Rezoning Transportation Analysis

Petition Number: #2022-090

Date	Description
11-28-22	First Review (TM)
01-25-23	Second Review (TM)
03-23-23	Third Review (TM)

RZ1.00

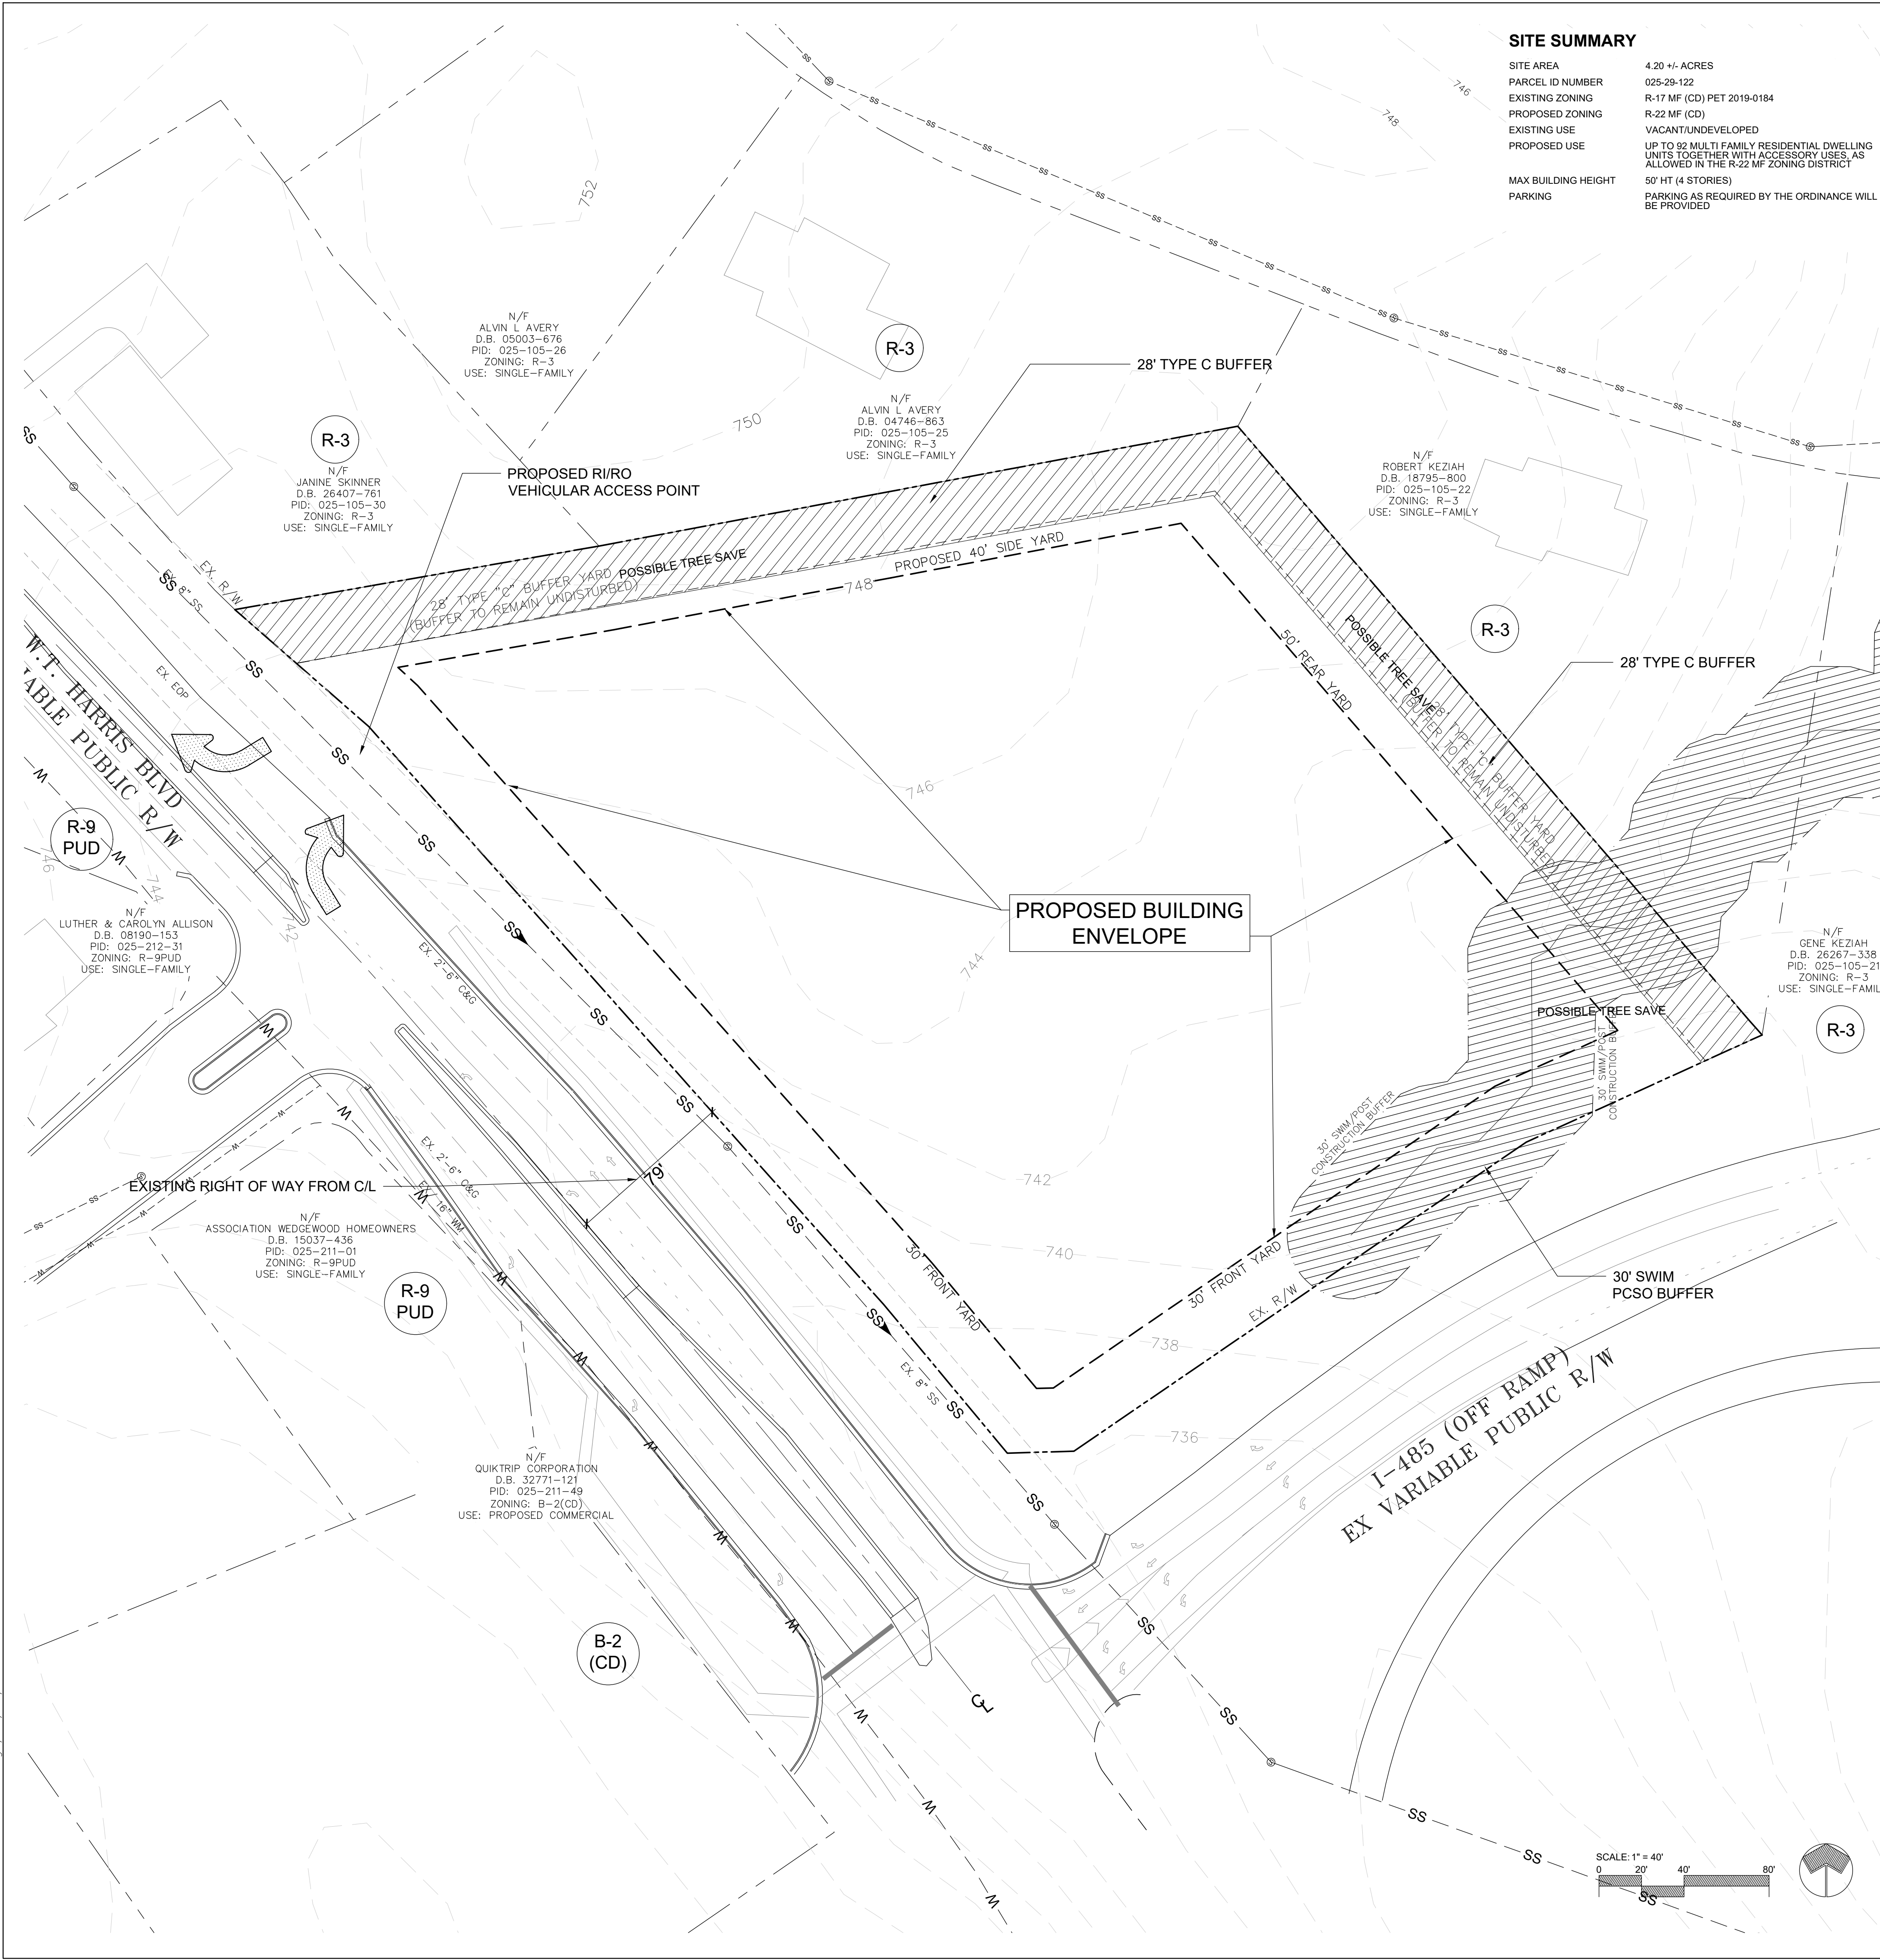
4. Site plan and conditional note(s) revisions are needed to commit to construct curb and gutter from existing curb and gutter to the Northern property line of the site. Curb and gutter shall be labeled and dimensioned from the centerline of WT Harris Boulevard on the site plan.

Outstanding Comment from 01-25-23: label and dimension curb and gutter on the site plan.

Clarifying Comment (01-25-23): Driveway stem is measured from proposed right-of-way. Site plan revisions are needed to show a internal driveway stem from the right of way line

Remove existing conditional note 3D.
